MEMORANDUM

TO: Jean Fraser, Planner
FROM: David Senus, PE
DATE: March 29, 2016
RE: Second Tee Condominium Association Business Park, Level II Amended Site Plan Application

Woodard & Curran has reviewed the Level II Amended Site Plan Application for the proposed development located at 1039 Riverside Street in Portland, Maine. The project involves the construction of the Unit 2 building, parking, utilities, and ancillary features.

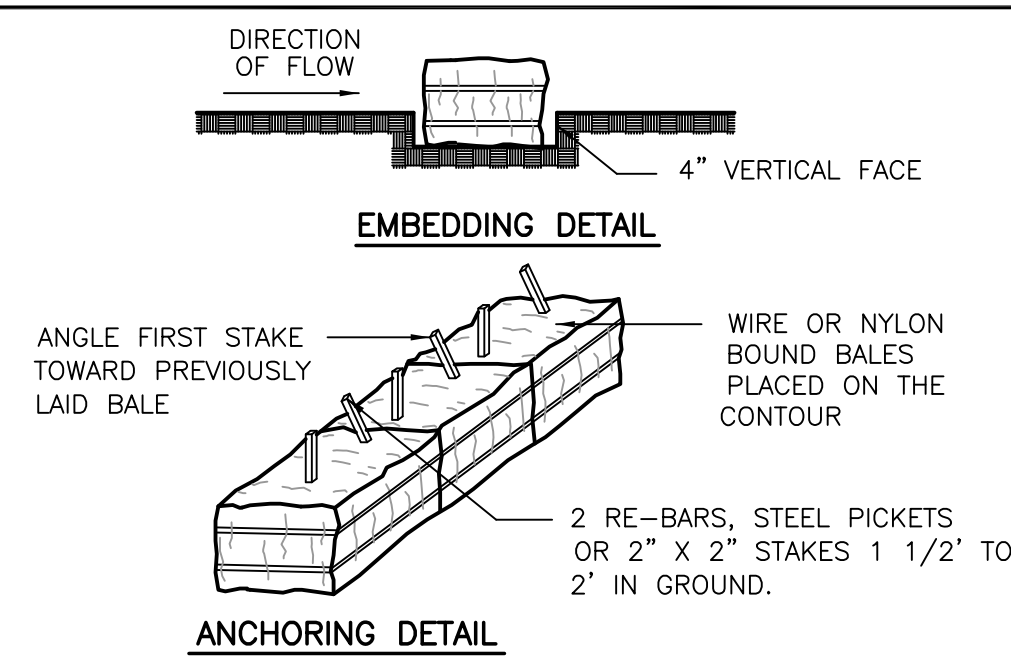
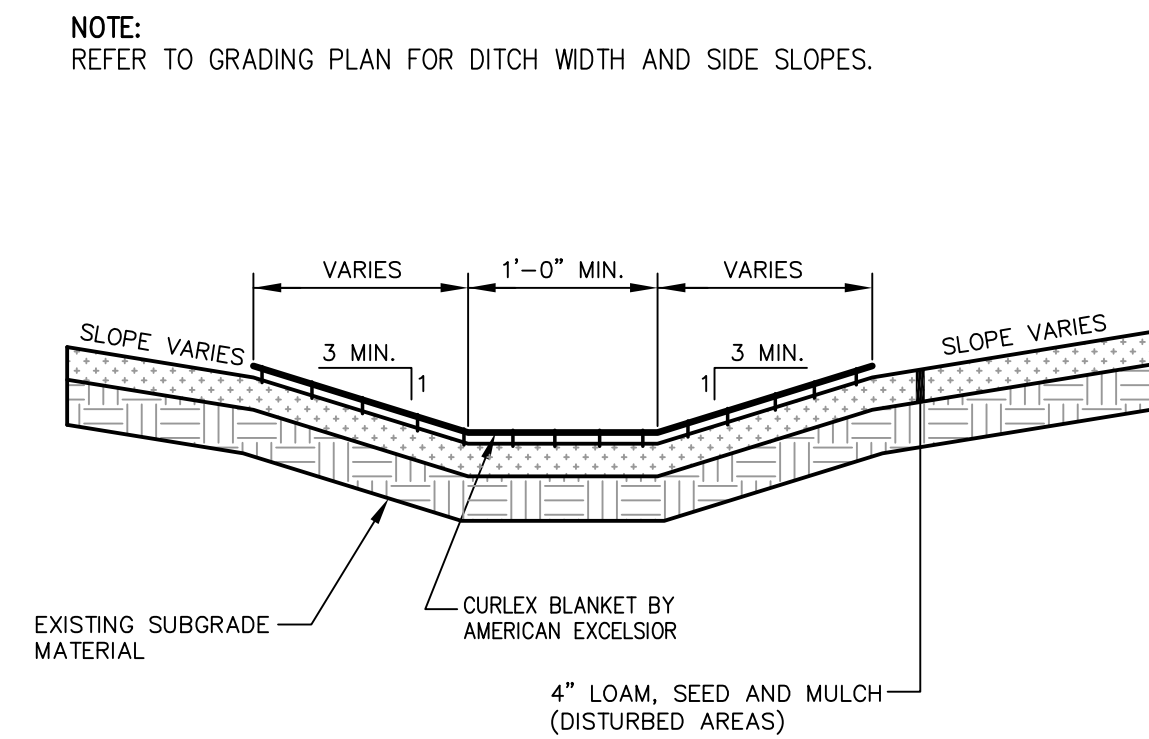
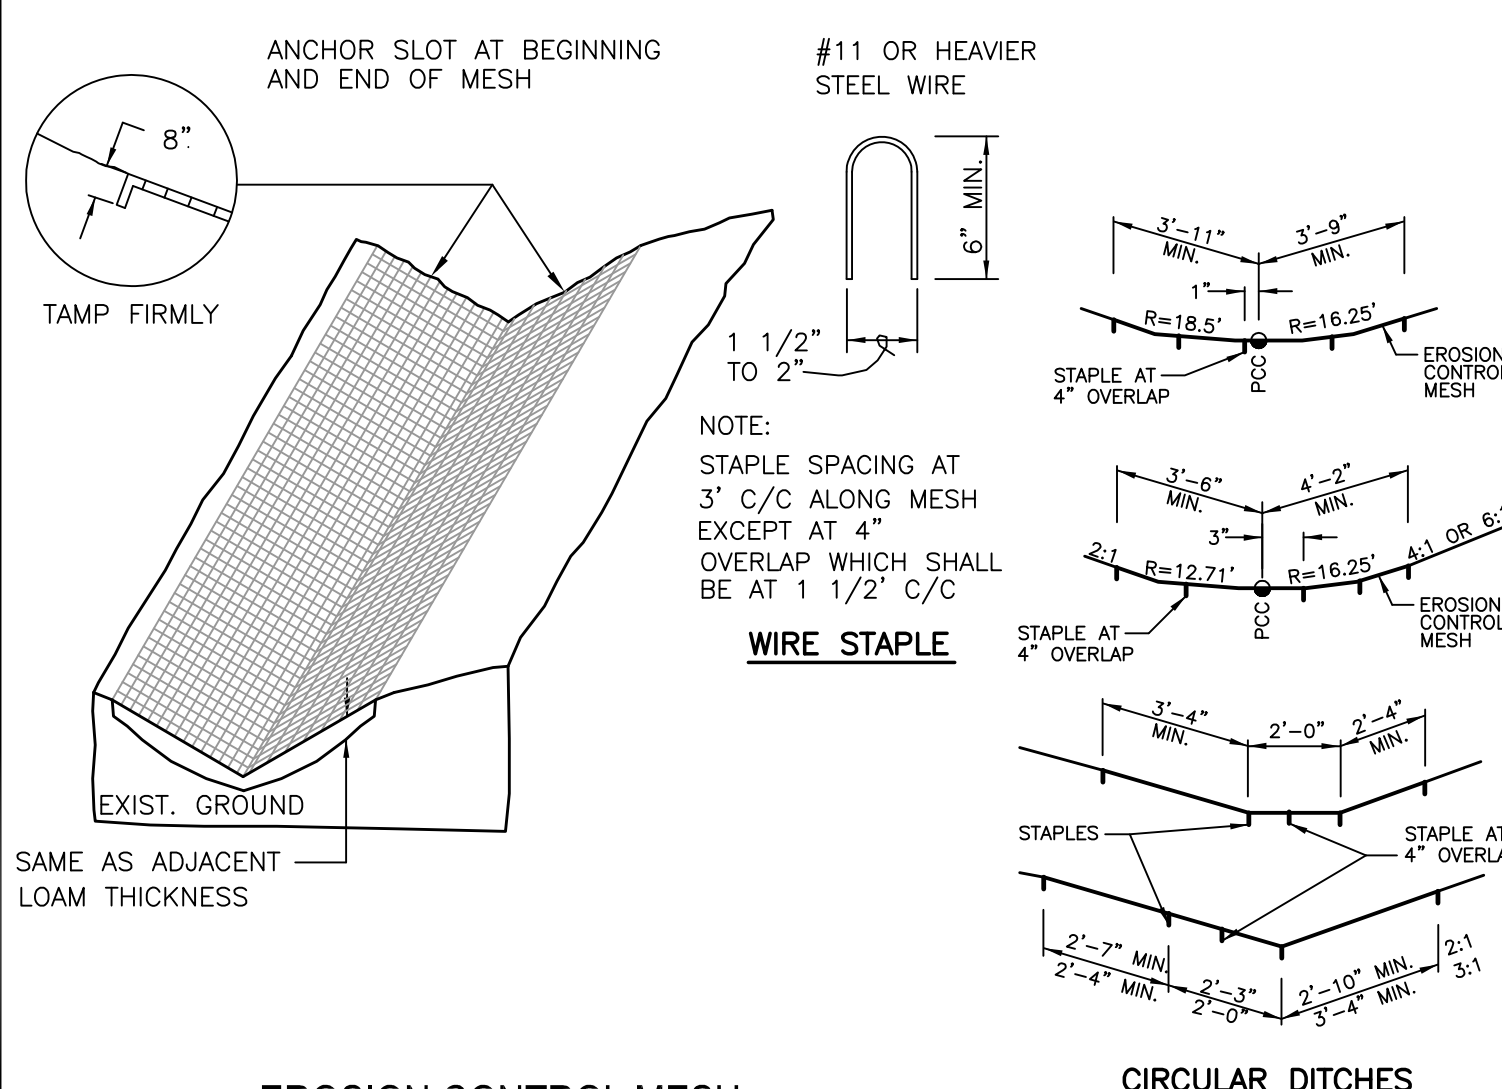
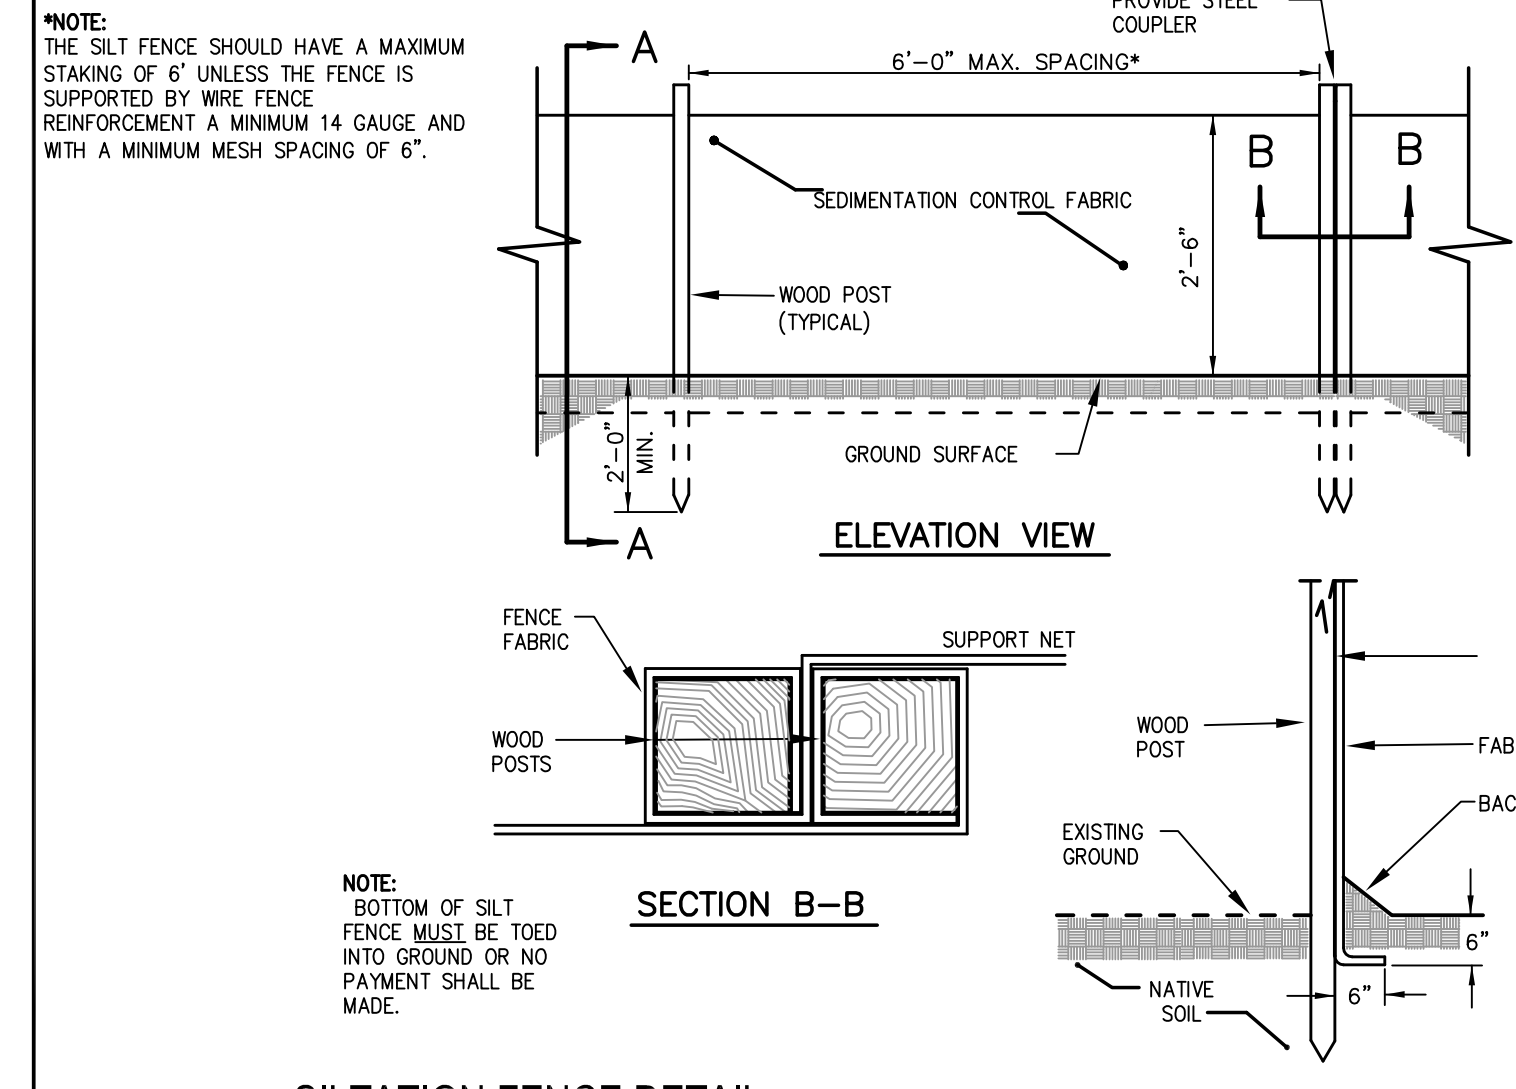
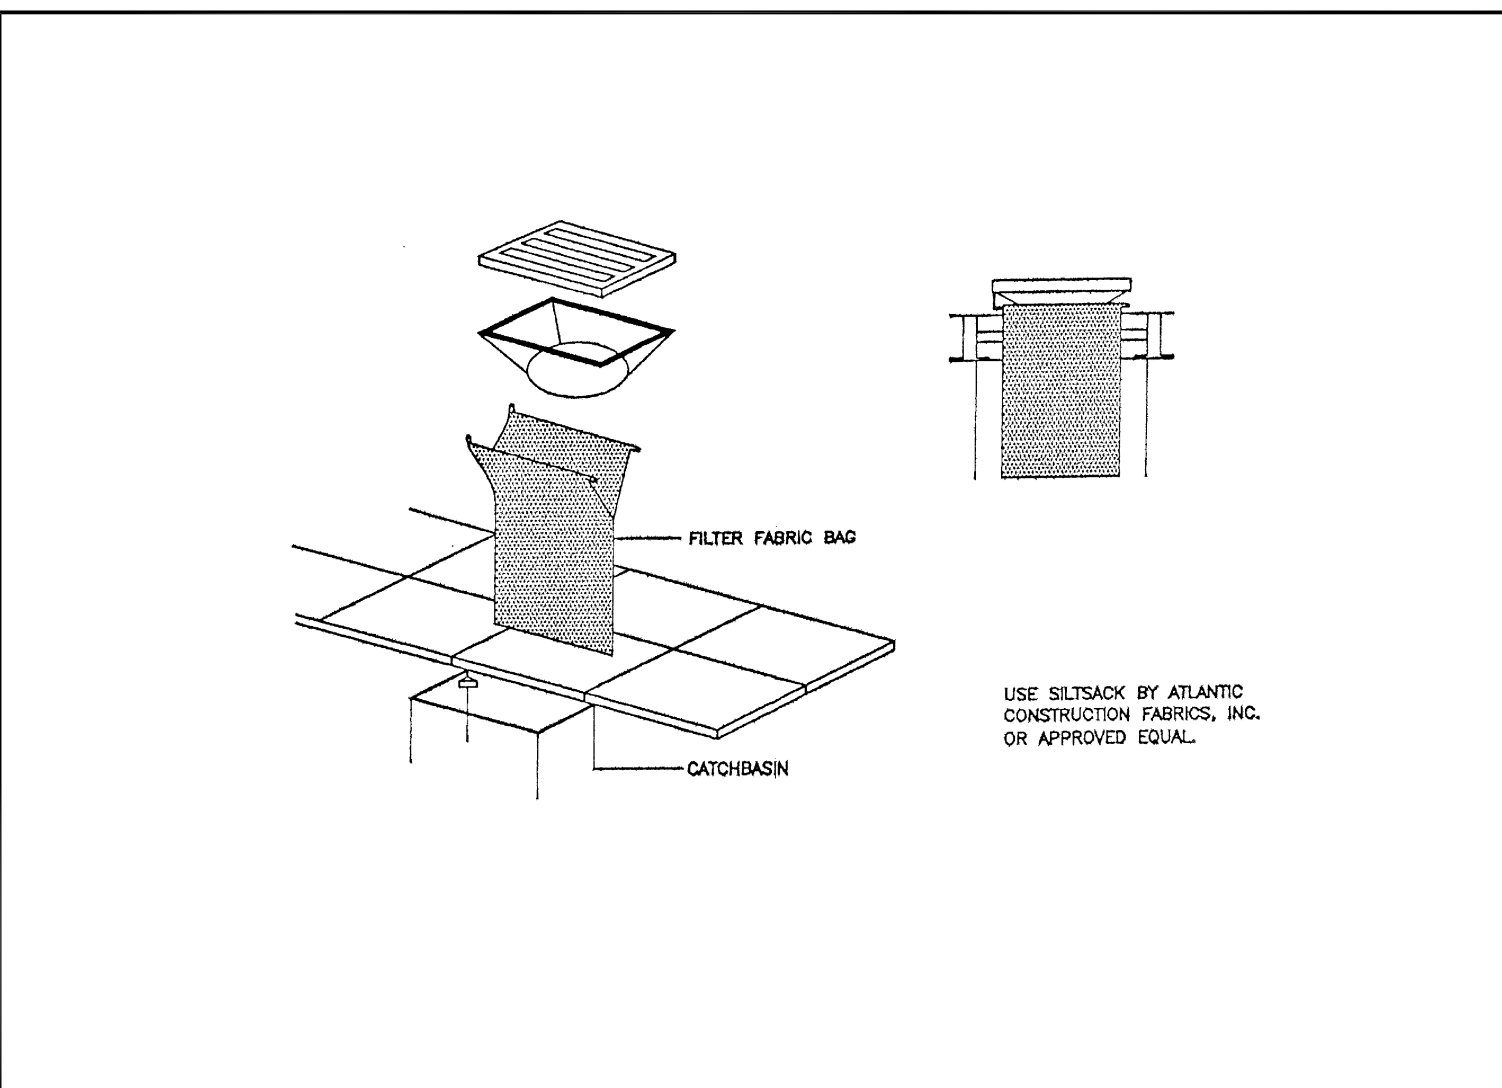
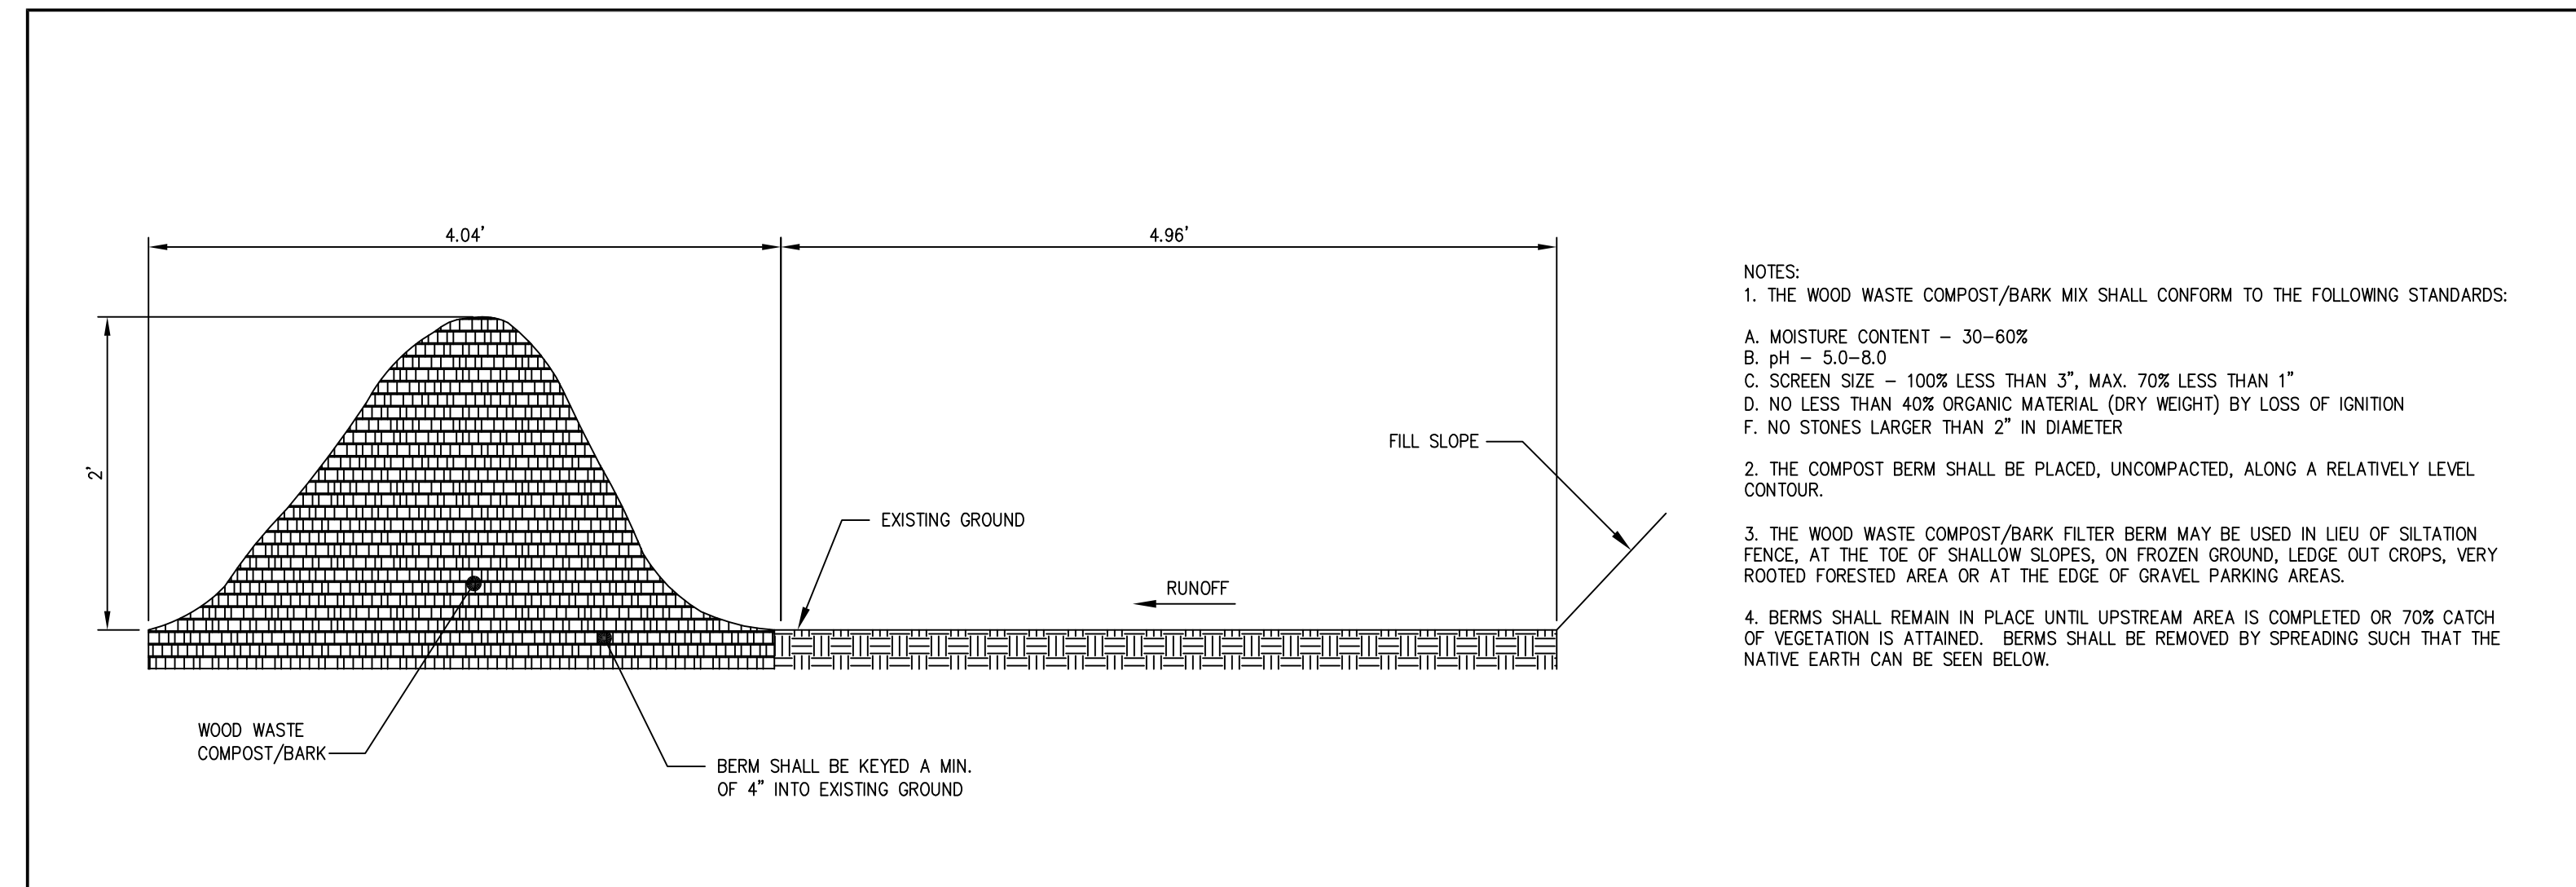
- a) Basic Standard: Plans, notes, and details have been provided to address erosion and sediment control requirements, inspection and maintenance requirements, and good housekeeping practices in general accordance with Appendix A, B, & C of MaineDEP Chapter 500.
